## **Sturton by Stow and Stow Neighbourhood Planning Group – Examination Submission for Cottam Solar.**

This report sets out the work of the reconvened Sturton by Stow and Stow Neighbourhood Planning Group, who have been considering the proposals regarding the recent spate of applications for development of solar farms. There are now applications regarding: Cottam1, 2 and 3; West Burton 1, 2 and 3; Gate Burton; Tillbridge Solar and Stow Park (Luminous), three of which affect our parishes, particularly Cottam 1.

Figure App.13.5-16:
ZTV from Coates medieval settlement
NHLE 1016979)

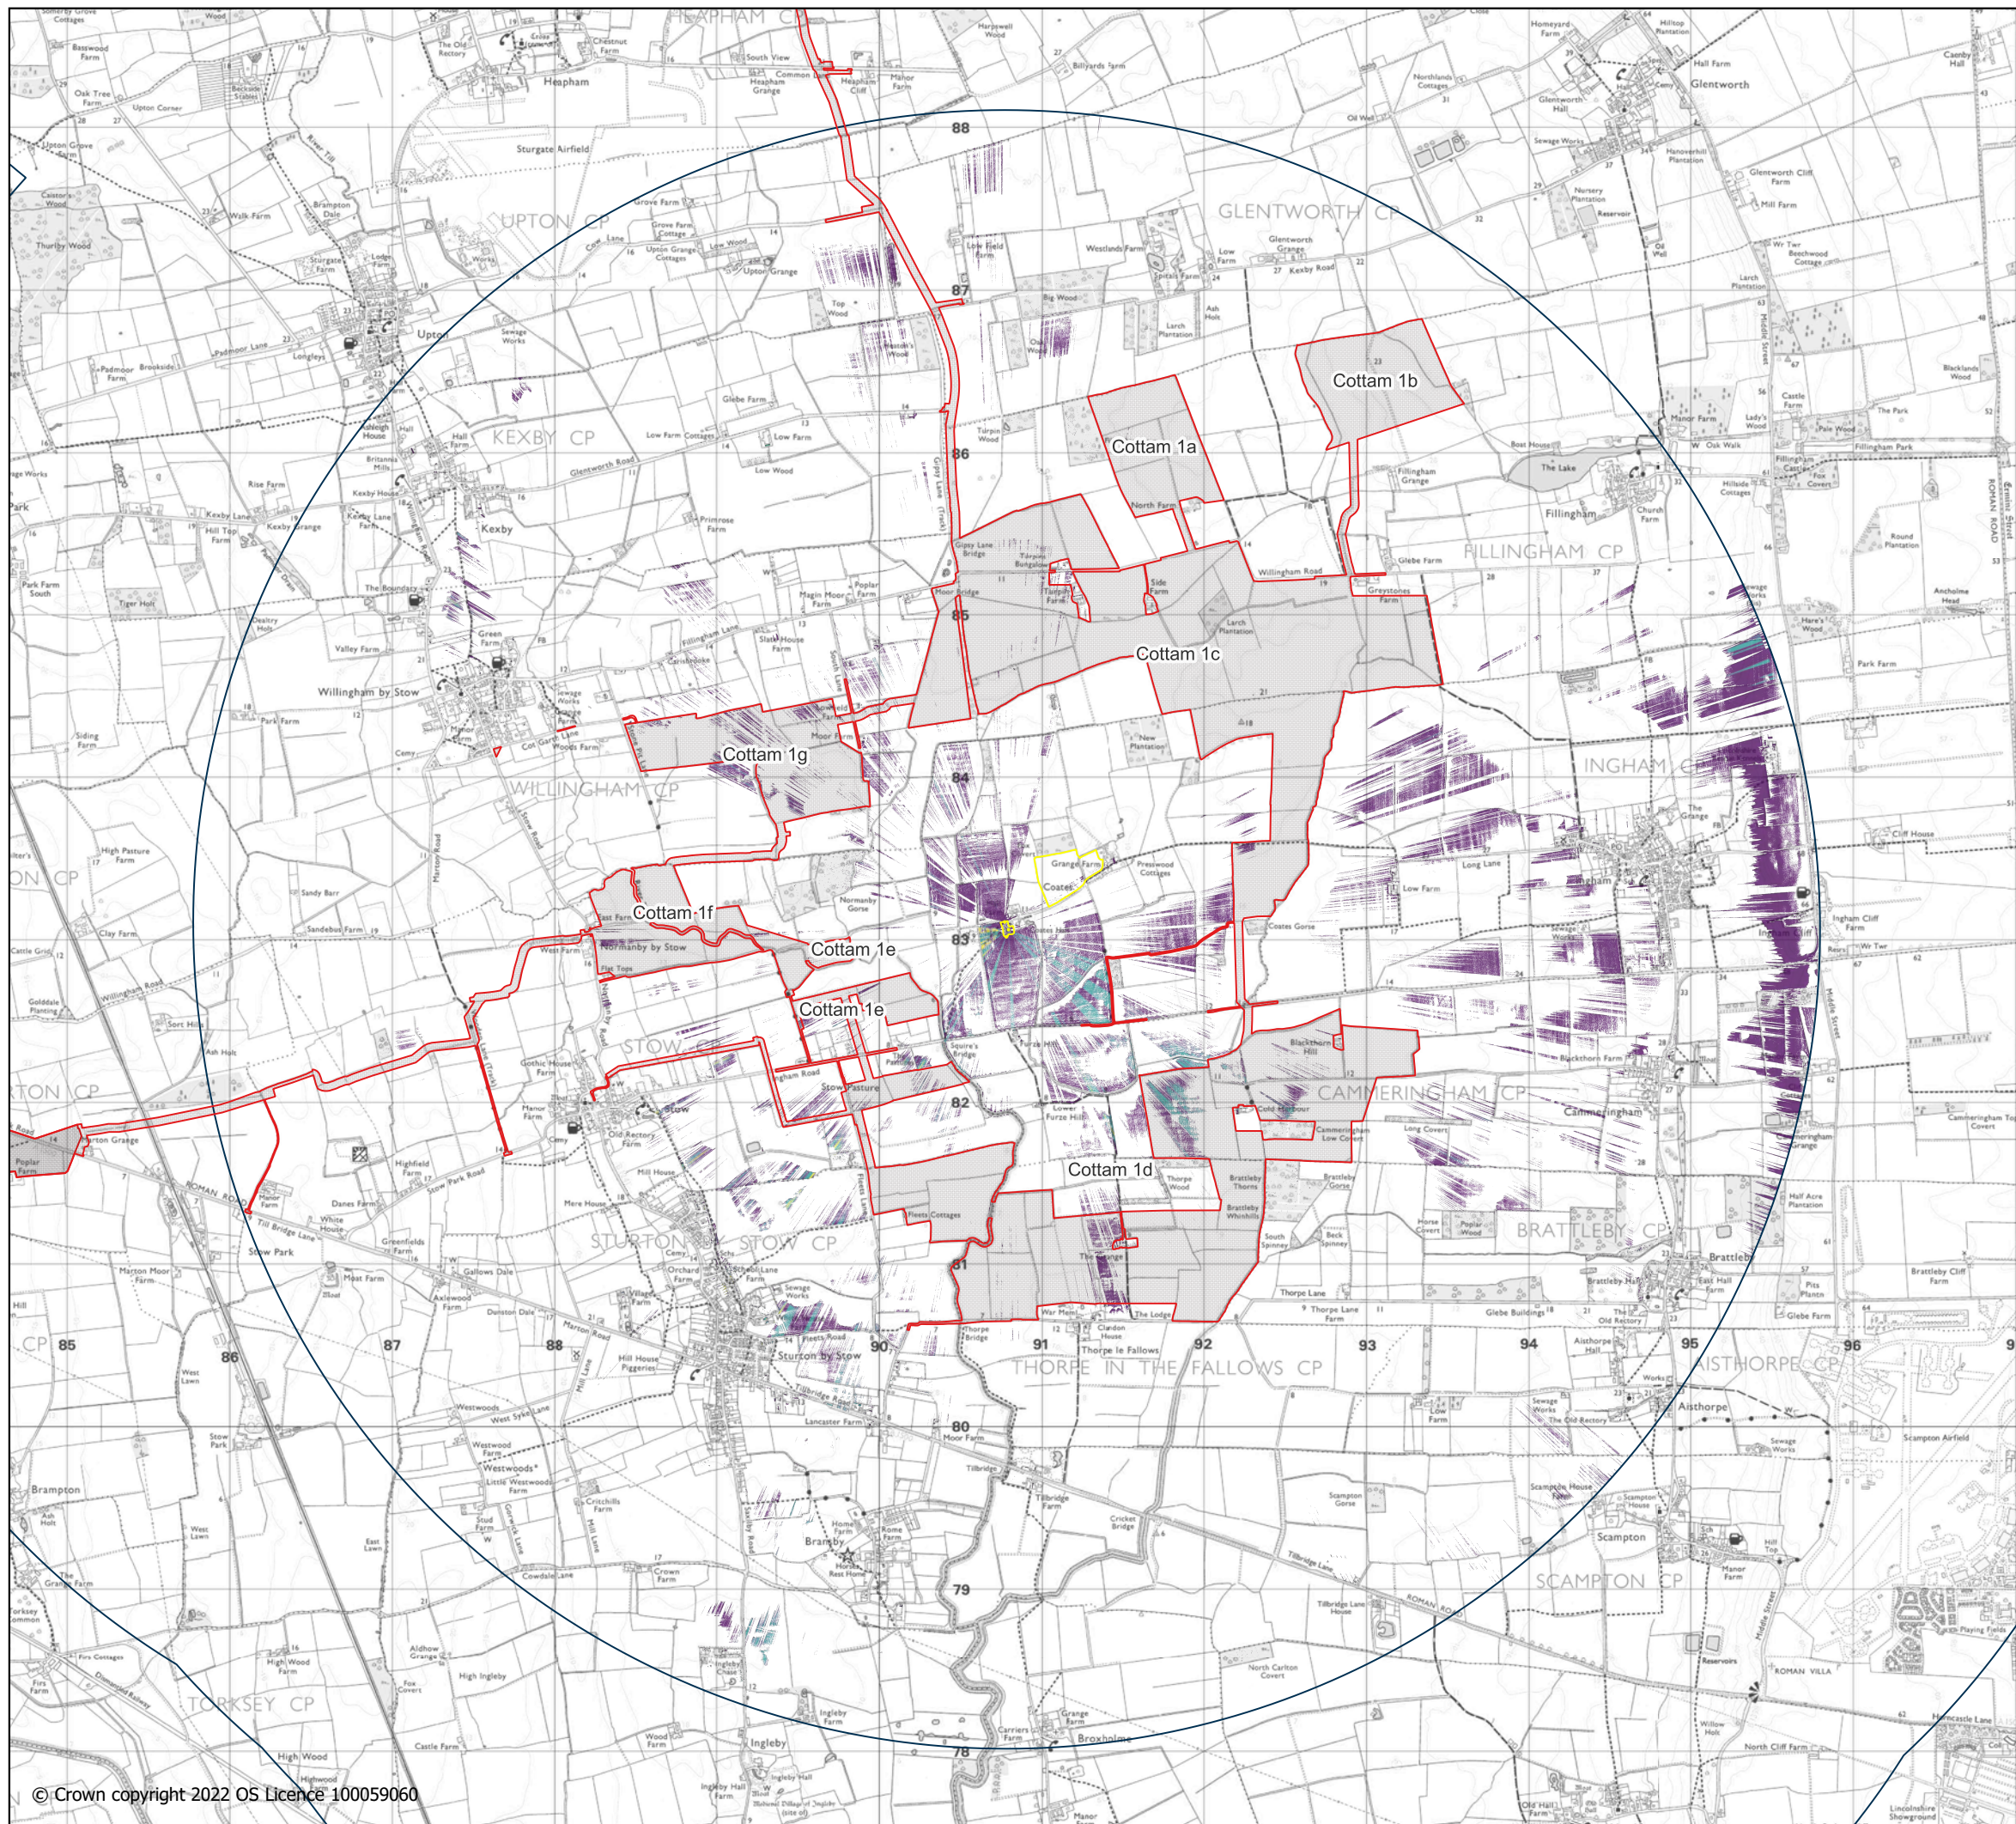
The proposed location of solar panels in the area around Coates cannot be seen in any way to *"preserve or enhance the character or appearance of the historic settlements, listed buildings and their settings"*.

Figure 5.3 Cottam 1 West Construction Vehicle Route

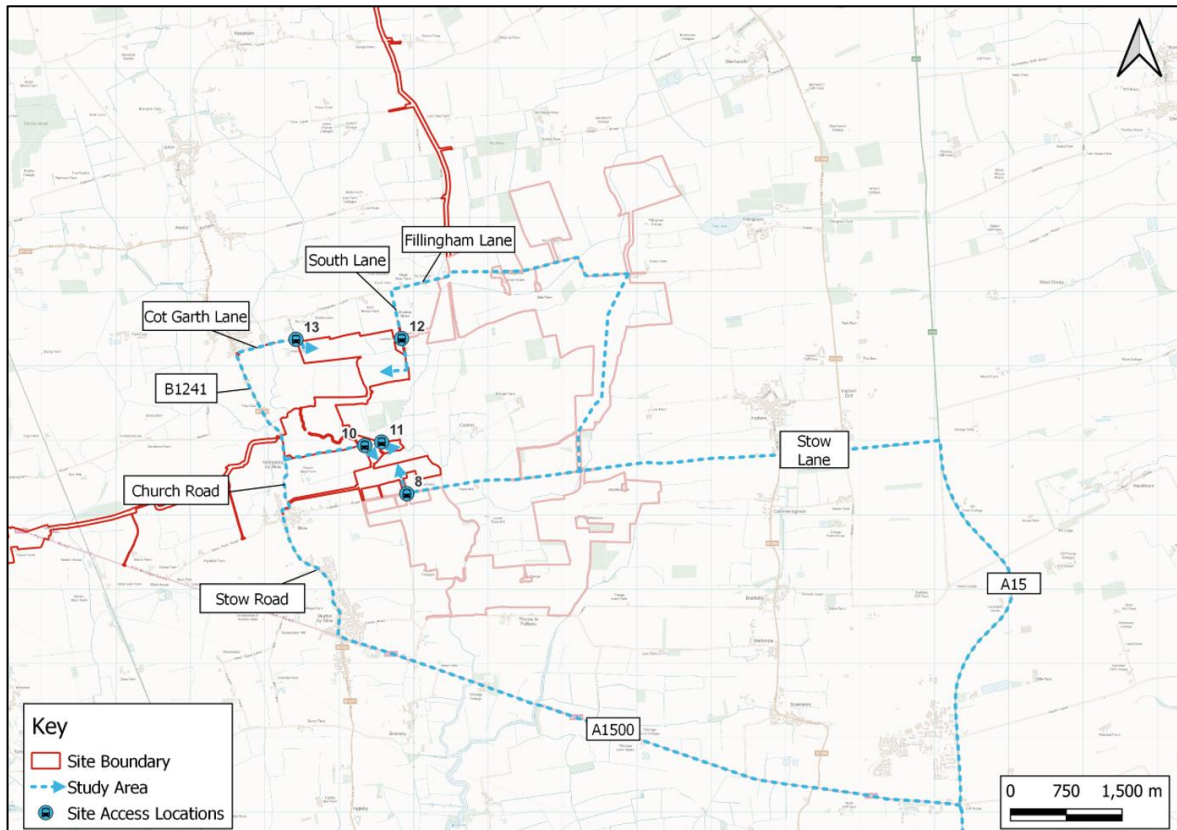
There are major concerns about the impact of the construction phase. The proposed route brings large vehicles through Stow, along Normanby Road, round some narrow bends before cutting across a ridge and furrow field. The narrow bends go past St Mary's, a Scheduled Monument.

**Section 13.8.** – in particular 13.8.5 *"The only potential direct physical impact to a designated heritage asset is the potential for damage to the wall of the churchyard at the Site of a college and Benedictine Abbey, St Mary's Church (NHLE 1012976) during construction. This is due to the fact that HGVs delivering abnormal loads will*

*need to mount the pavement adjacent to the Scheduled Monument, but this can be mitigated by the close monitoring of these manoeuvres by a suitably qualified banksman to ensure that this potential adverse impact can be avoided.”*

Is this really adequate protection of a such an important site? Perhaps an alternate route should be sought.
